21 April 2026

Ref No: F2025/00309

RE: MOD 6 IXOM Chlorine Liquefaction Plant (DA35/98-Mod-6 - Submissions Report)

Figure 3.1: Site location and surrounding land uses

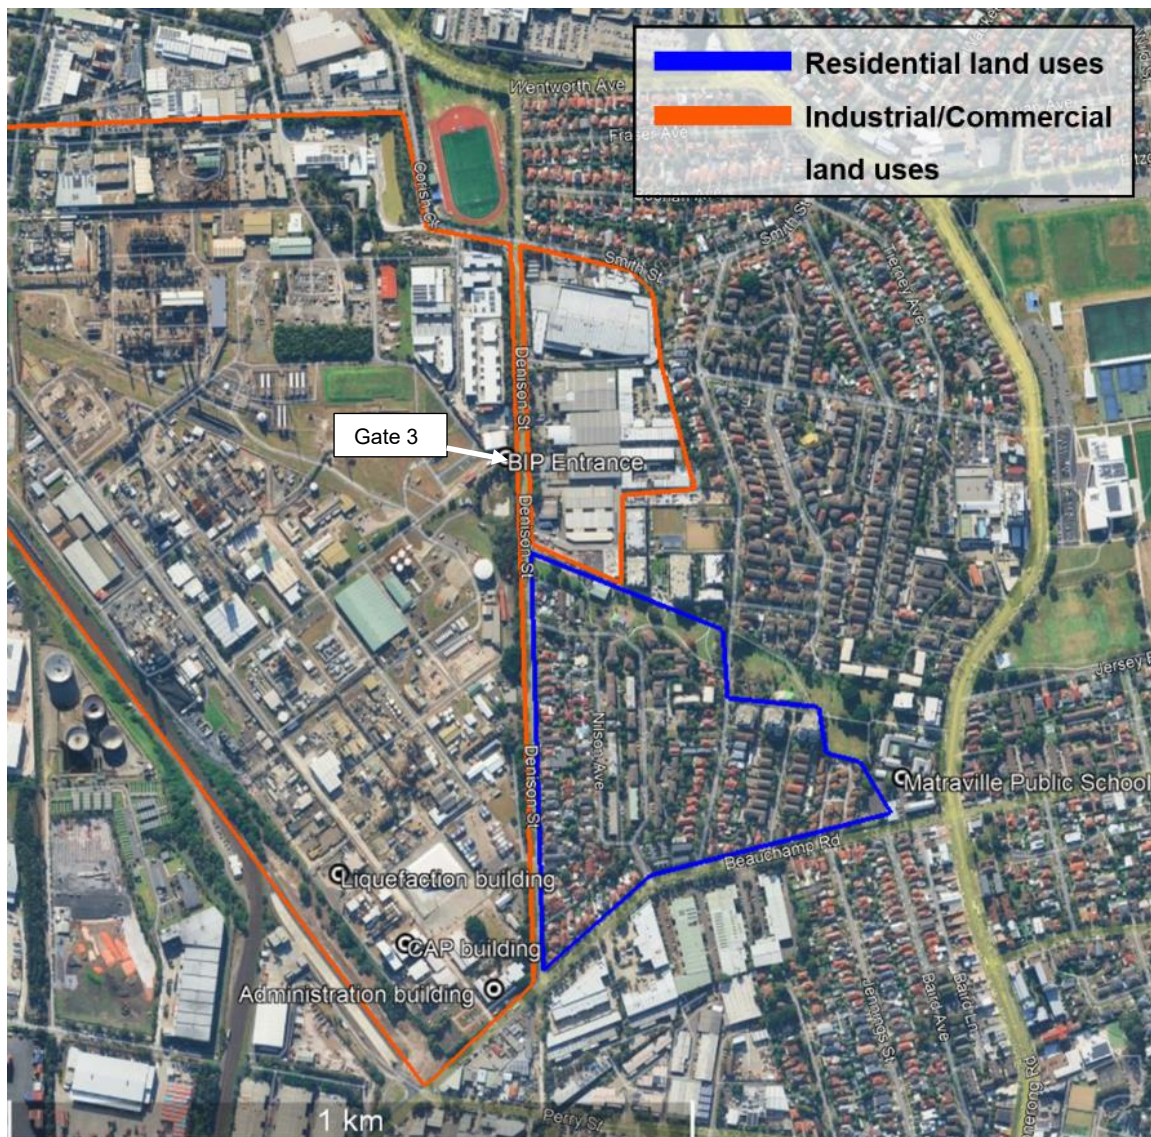
Council maintains its concern that the proponent's risk assessment demonstrates irritation injury contours extending beyond the site boundary into the adjoining Banksmeadow Recycling Yard at 38 McPherson Street, a publicly accessible facility.

The RTS acknowledges this extension but seeks to downplay its planning significance by characterising the land use as "industrial/commercial" and therefore safe for industrial workers. Council does not agree that this approach is consistent with the intent or application of HIPAP 4, which is directed to also protecting members of the public visiting the recycling yard regardless of whether the land is described as industrial or commercial.

The consent holder shall ensure that no land accessible to the public is located within any off-site injury or irritation hazard contour arising from the operation of the proposed chlorine liquefaction plant, as identified in the approved risk assessment. Where such exposure is identified, operations shall be modified or curtailed until compliance is achieved.

Figure 7.2: IFR for cases 1 & 2 – Current chlorine transport (left) and future chlorine transport (right)

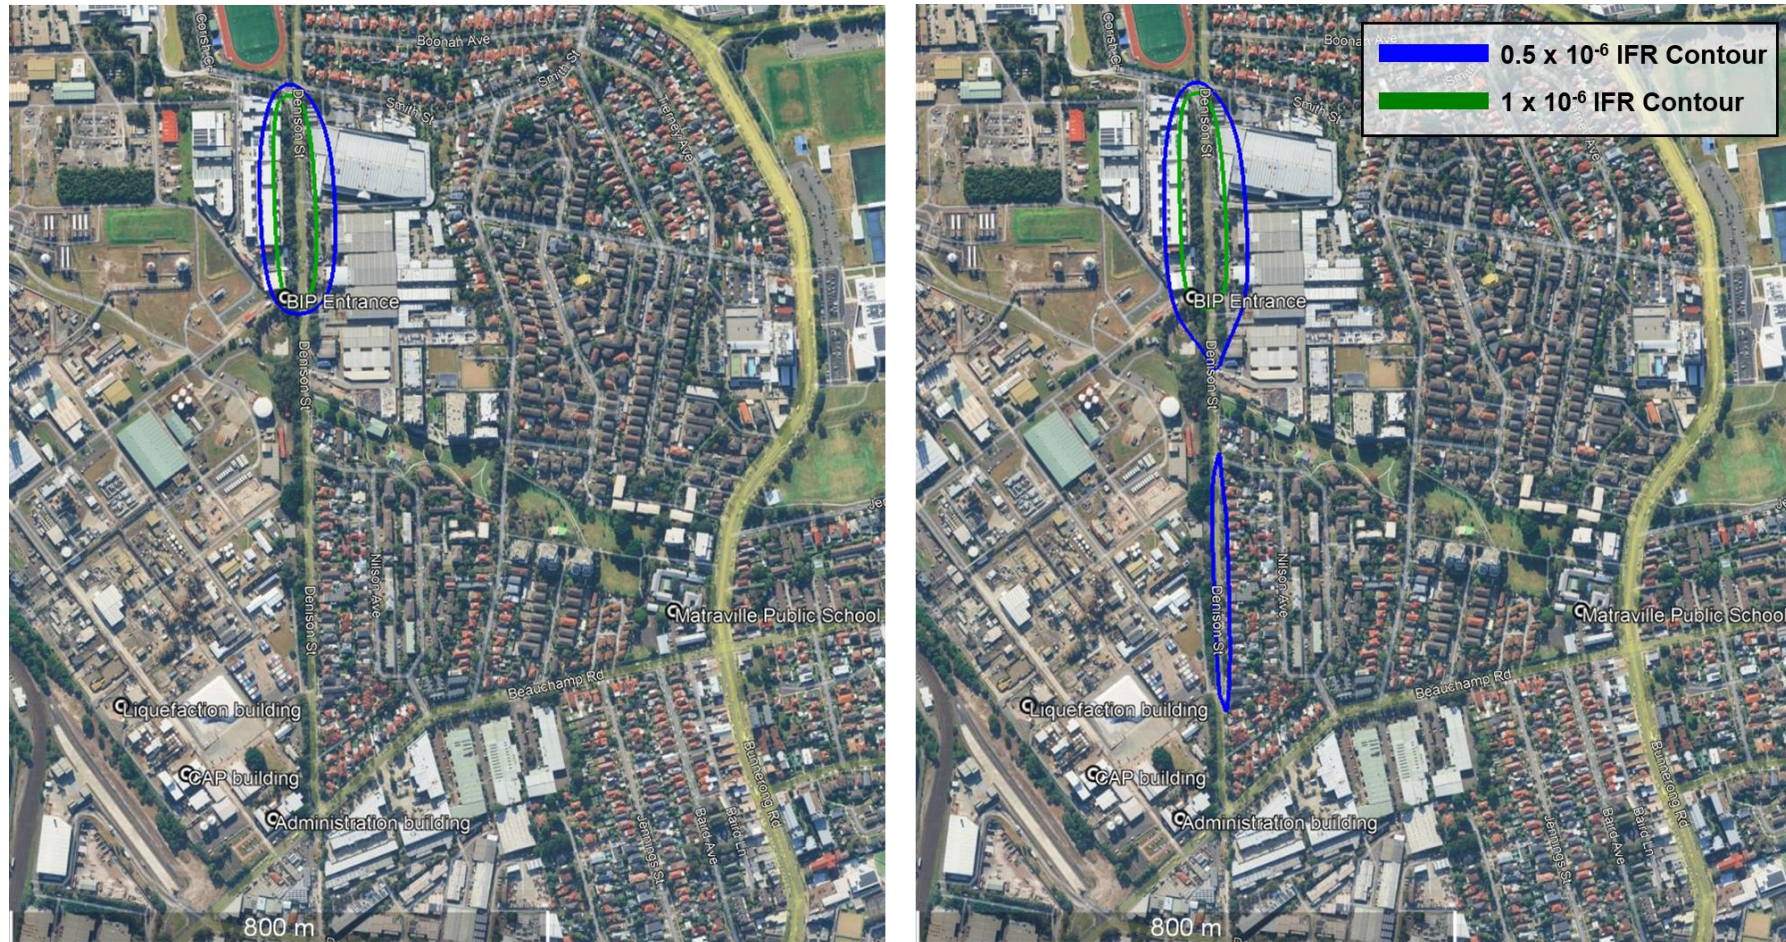
Council remains concerned that the RTS does not address the deficiencies previously identified in relation to dangerous goods transport and cumulative risk, including that:

- the transport and risk assessment still relies on outdated or modelled traffic data rather than current, site-specific traffic counts, meaning it may not reflect how the surrounding road network is actually being used today.
- the cumulative risk assessment departs from the baseline framework required by the SEARs and instead relies on an alternative model that has not been independently validated.
- the assessment acknowledges residential risk levels along Denison Street exceed accepted thresholds yet does not propose any enforceable measures to reduce those risks.
- there are no binding controls to manage tanker movements, queuing or peak-period traffic under contingency operating scenarios.

Prior to the commencement of operations, the consent holder shall undertake updated, site-specific traffic and dangerous goods movement counts on Denison Street to verify the cumulative transport risk baseline required by the Secretary's Environmental Assessment Requirements. The results shall be submitted to the Department for endorsement and, where actual traffic conditions differ materially from those assumed in the approved assessment, the consent holder shall implement measures to address cumulative transport risk to the satisfaction of the Department before continuing operations.
